## **Representations by Highways England in respect of the proposed Northampton Gateway Strategic Rail Freight Interchange**

These are the Written Representations of Highways England in respect of the application by Roxhill Limited (the Applicant) for a Development Consent Order (DCO) to authorise a Strategic Rail Freight Interchange at Junction 15 of M1 Motorway.

**Drawing Title**  
 MAIN SITE  
 DRAINAGE STRATEGY

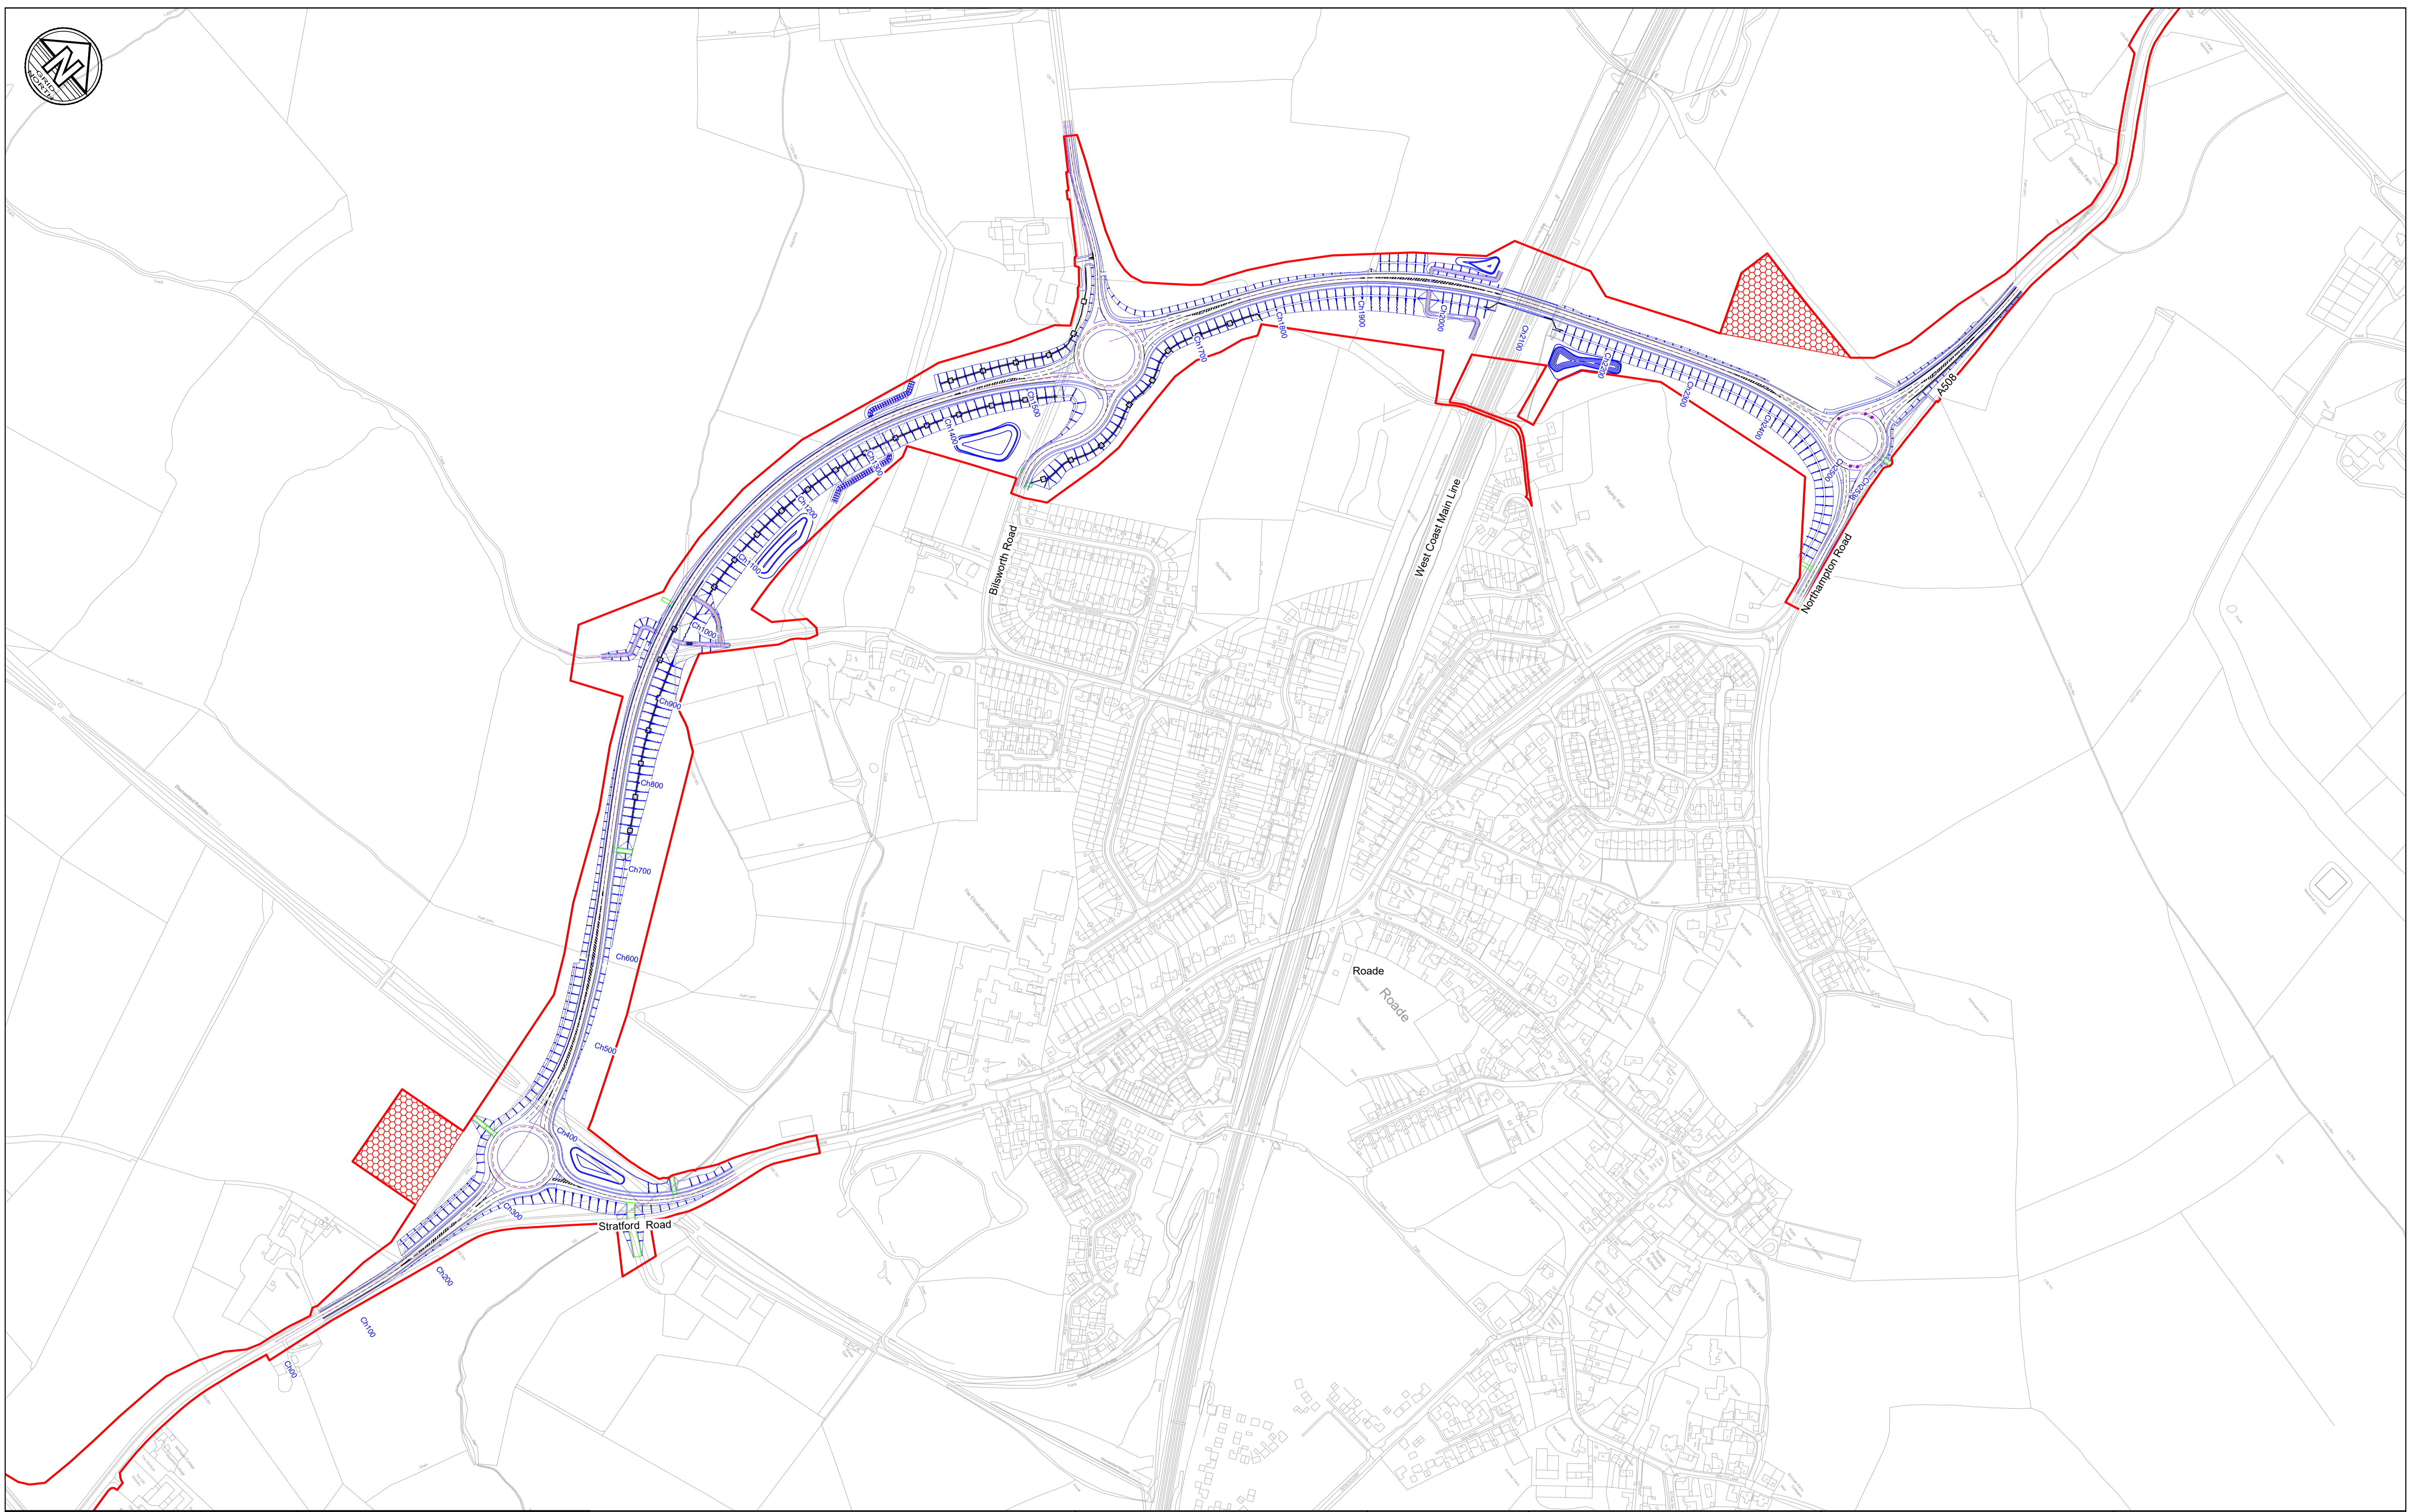
Specialists in Highways England's drainage team have reviewed the undertaker's Sustainable Drainage Statement. Highways England's has two main areas of concern in this regard which relate to the assessment of two of the main outfall locations - 'Collingtree village via 300mm culvert under M1 (to Wootton Brook)' and 'Wootton Brook (via culvert under M1 roundabout)'. The assessments are not considered to be satisfactory, for example there is no clarity of the existing gradient, structural or service condition of the pipes. Highways England requires further information to make an informed decision as to whether or not the proposals are acceptable.

The change of use of the application site will alter the current discharge rate for the site and therefore must be assessed against Dft Circular 02/2013. Based on information available to date Highways England cannot be certain that the undertaker's proposals will be acceptable in accordance with the Circular. We have proposed further work with the undertaker to obtain clarity and resolve this matter and we shall update the Examining Authority in due course.
